11 October 2011

**S.75W MODIFICATION TO MP10\_0057 – RESPONSE TO ISSUES  
132-138 KILLEATON ST, ST IVES**

**KU-RING-GAI COUNCIL LETTER**

DRAWING TITLE:
CARPARK PLANS

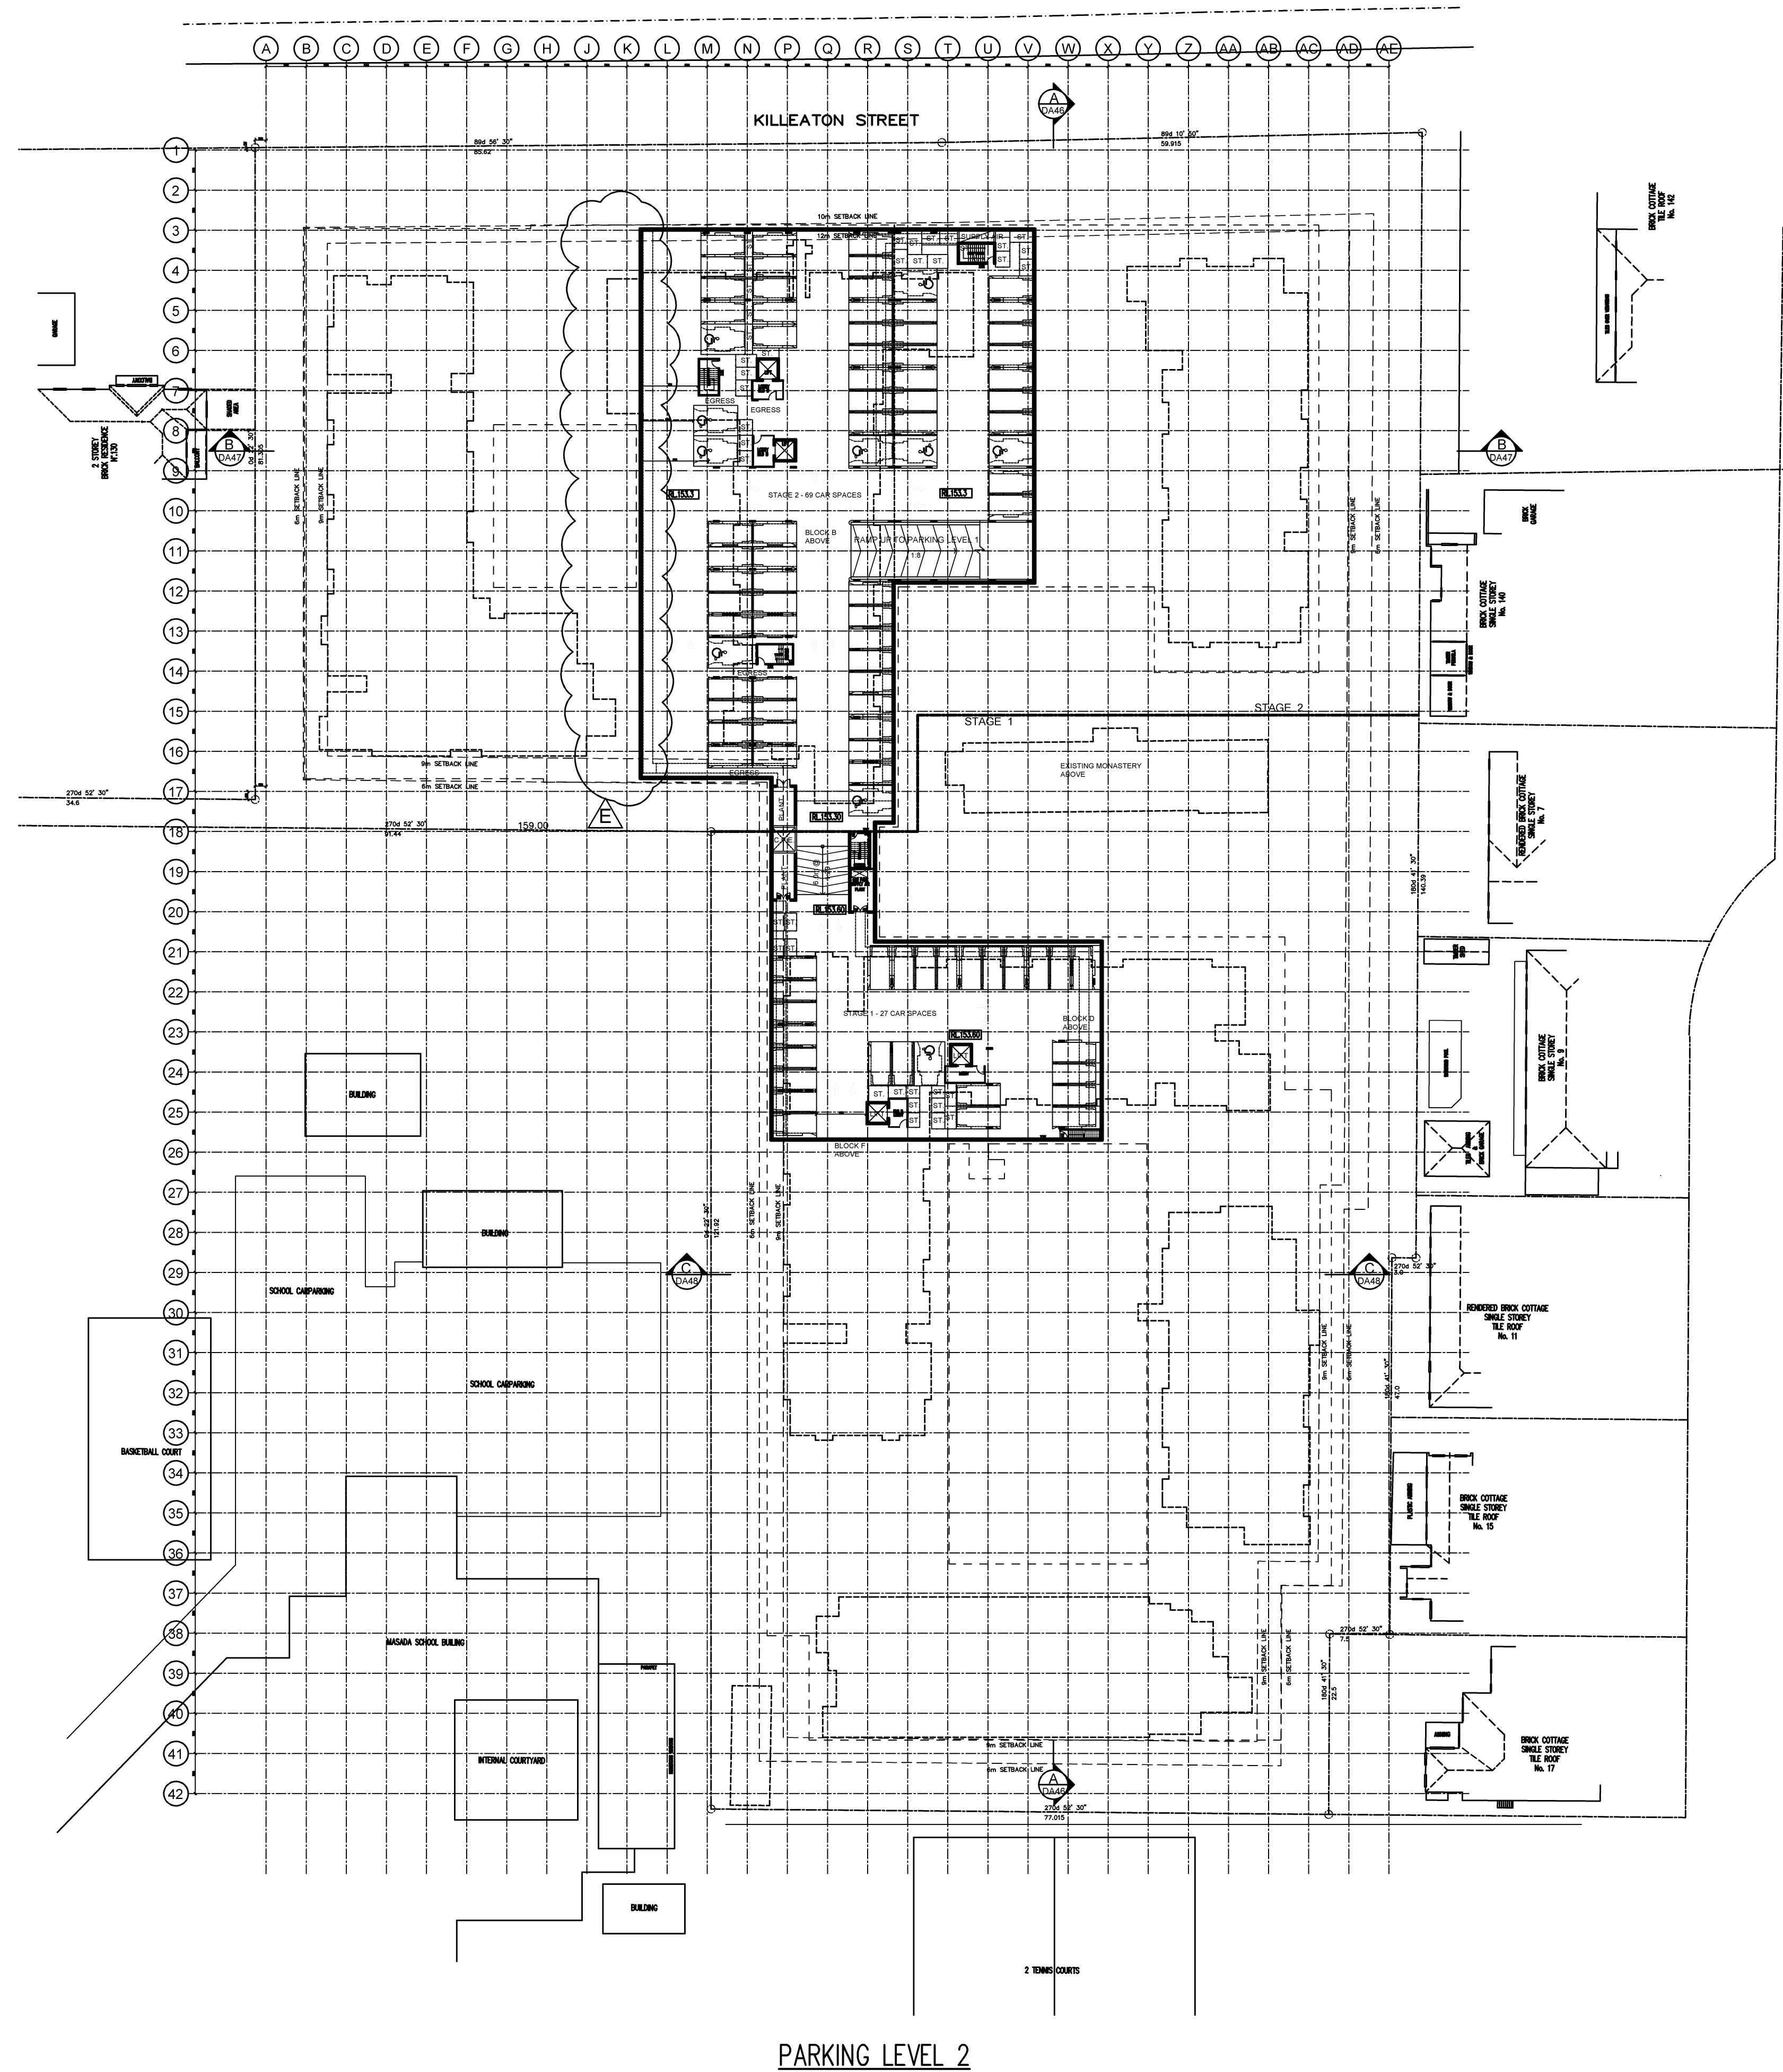
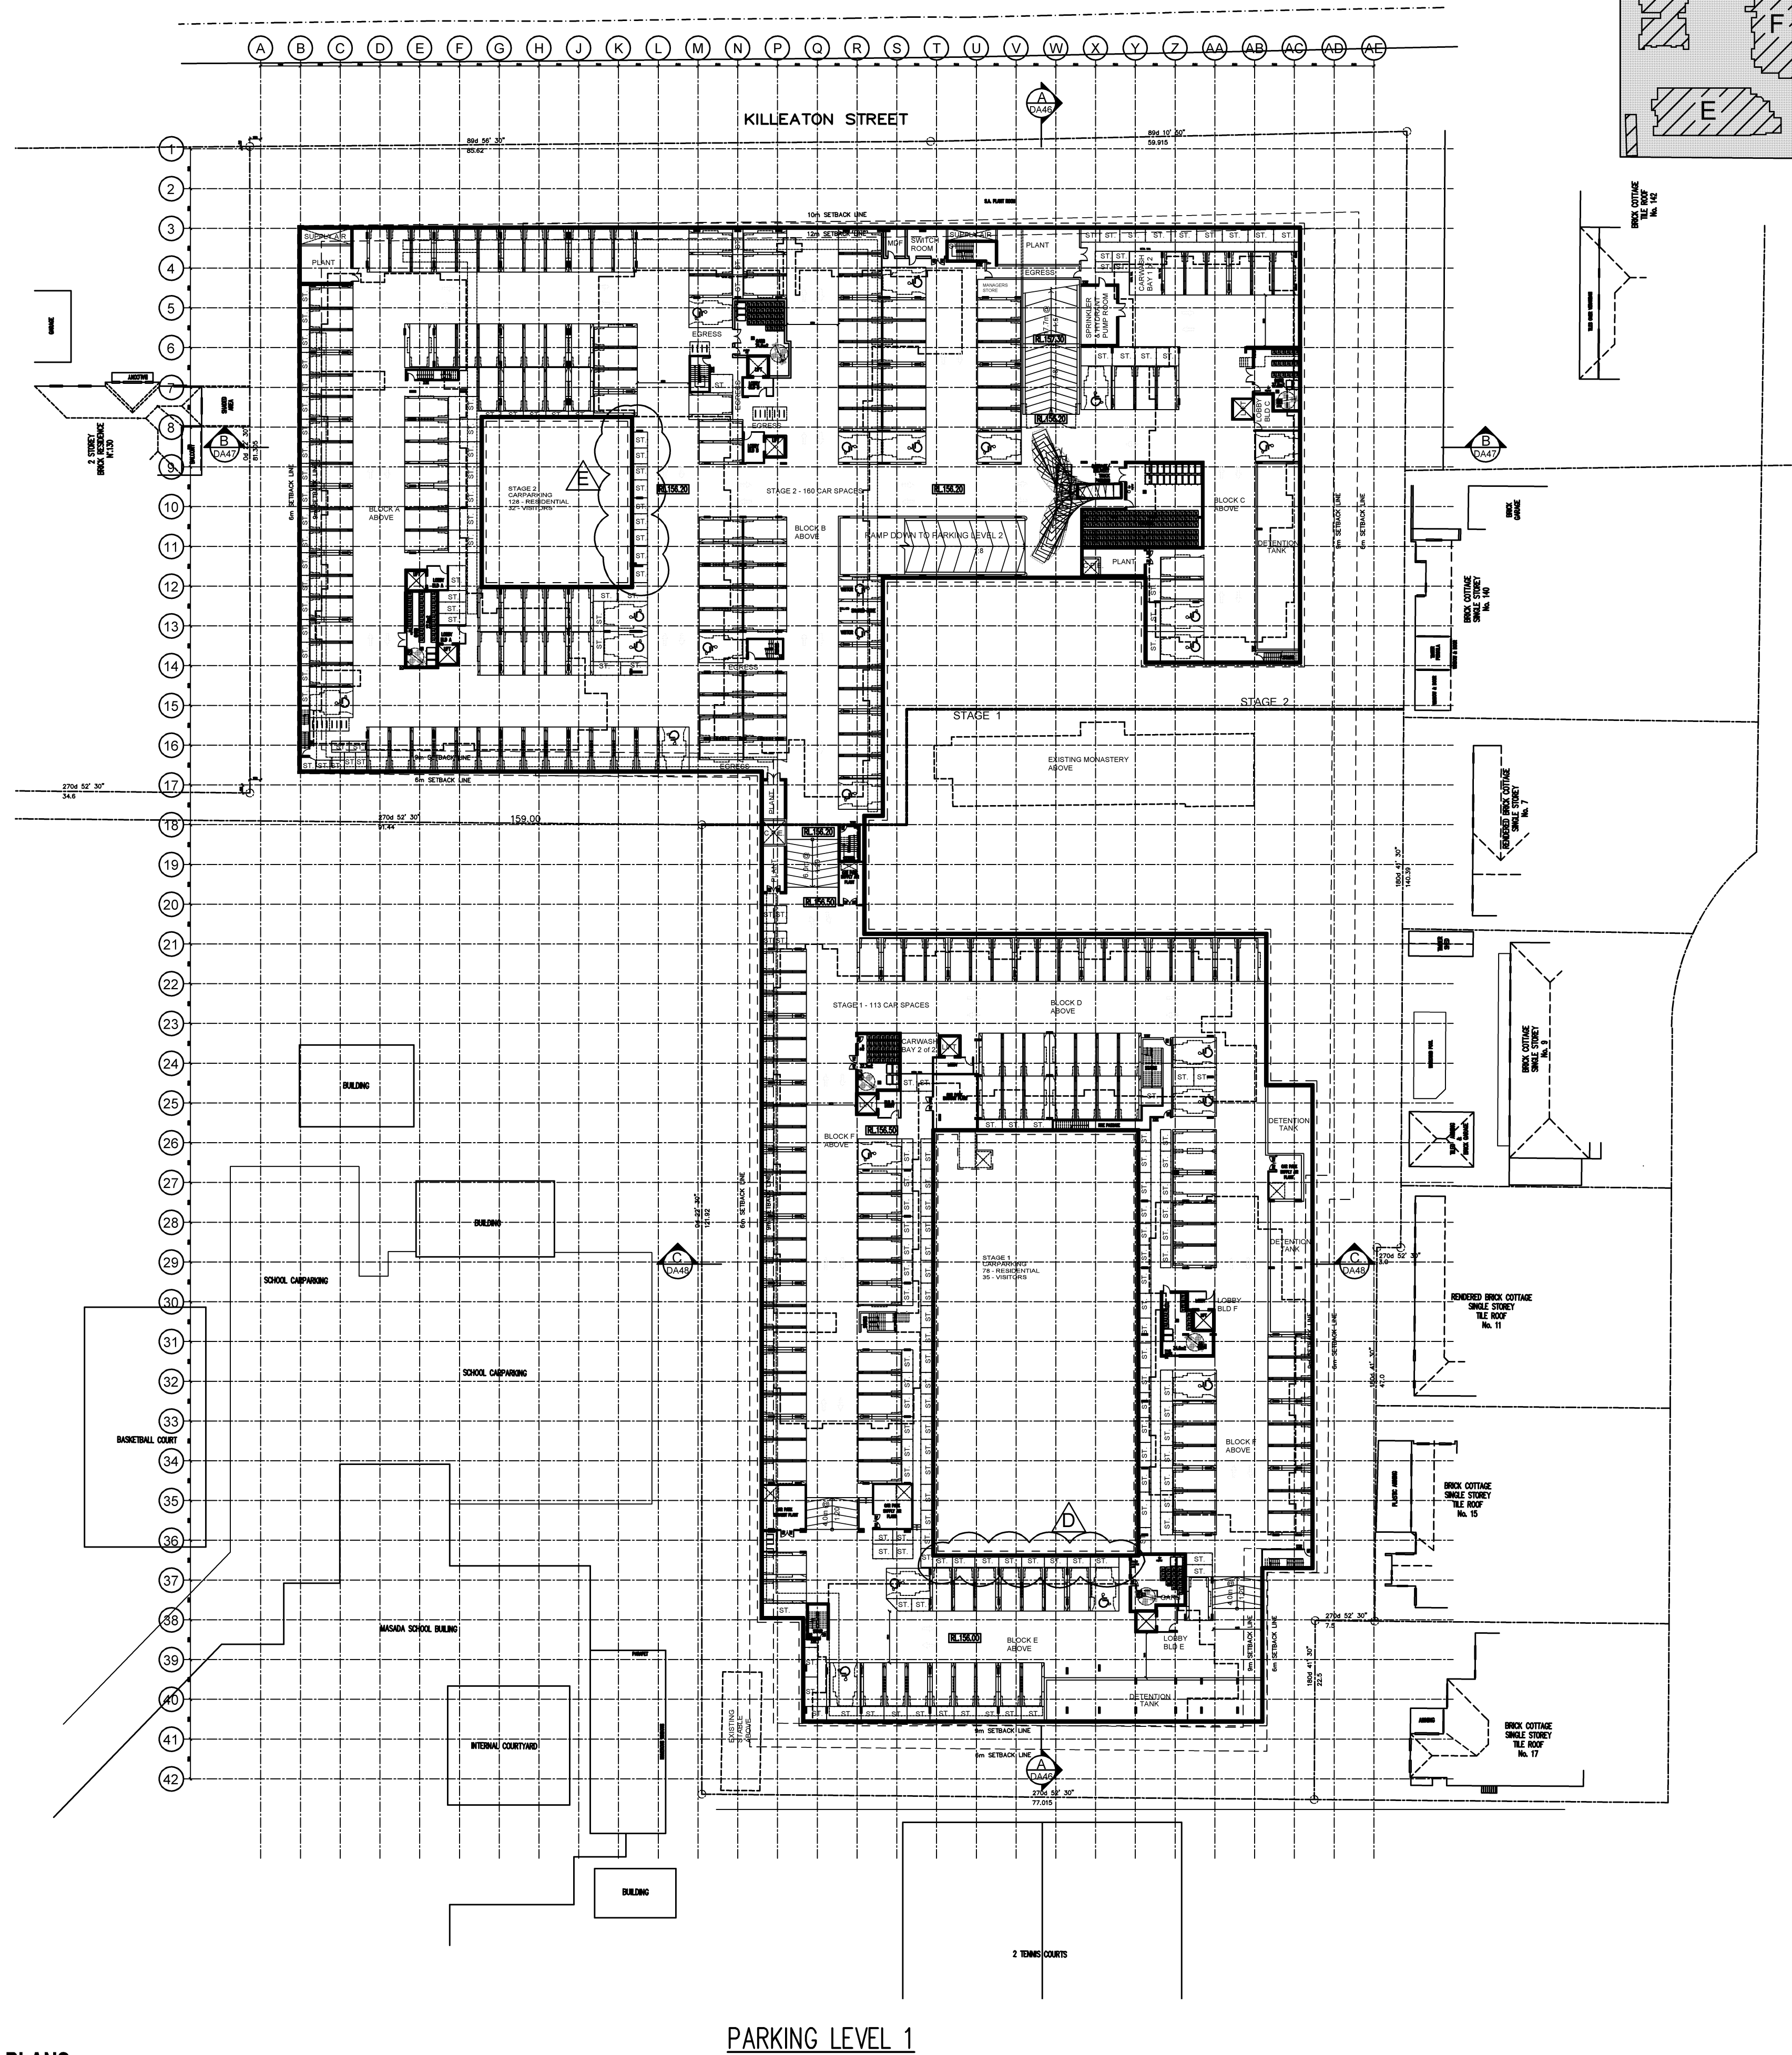
The Council argues that the visitor parking provision should remain at 75 parking spaces (instead of 48 as proposed) because the site is not located in a town centre or on railway line.

As detailed in our application and in the traffic report accompanying our application, the subject site is well serviced by bus transport. Those bus services include transport links to the nearby railway stations.

It is considered highly unlikely that 75 individuals (all of whom are driving a car) will be visiting the site at any one time. Indeed, it is also considered unlikely that 48 individuals (driving a car) would be visiting the site at any one time.

The Council's argument also relies on data that relates to resident parking. We seek no change to the resident parking provisions on the site.
